NORTH LEVEL DISTRICT INTERNAL DRAINAGE BOARD

Our ref: **HS/H19-1174-25**

Planning Reference: H19-1174-25
Proposed pair of semi detached houses
Land North of 291 Broadgate Road, Sutton St Edmund

Site Plan 1:200

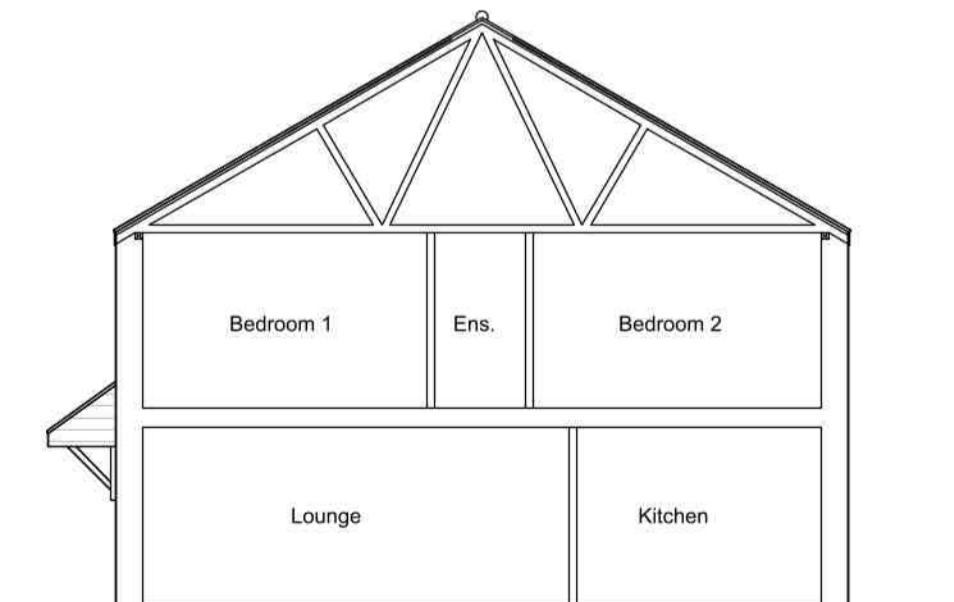
It has been noted that soakaways are indicated as the preferred method of surface water disposal. It needs to show that soakaway drainage would be effective in the plot layout.
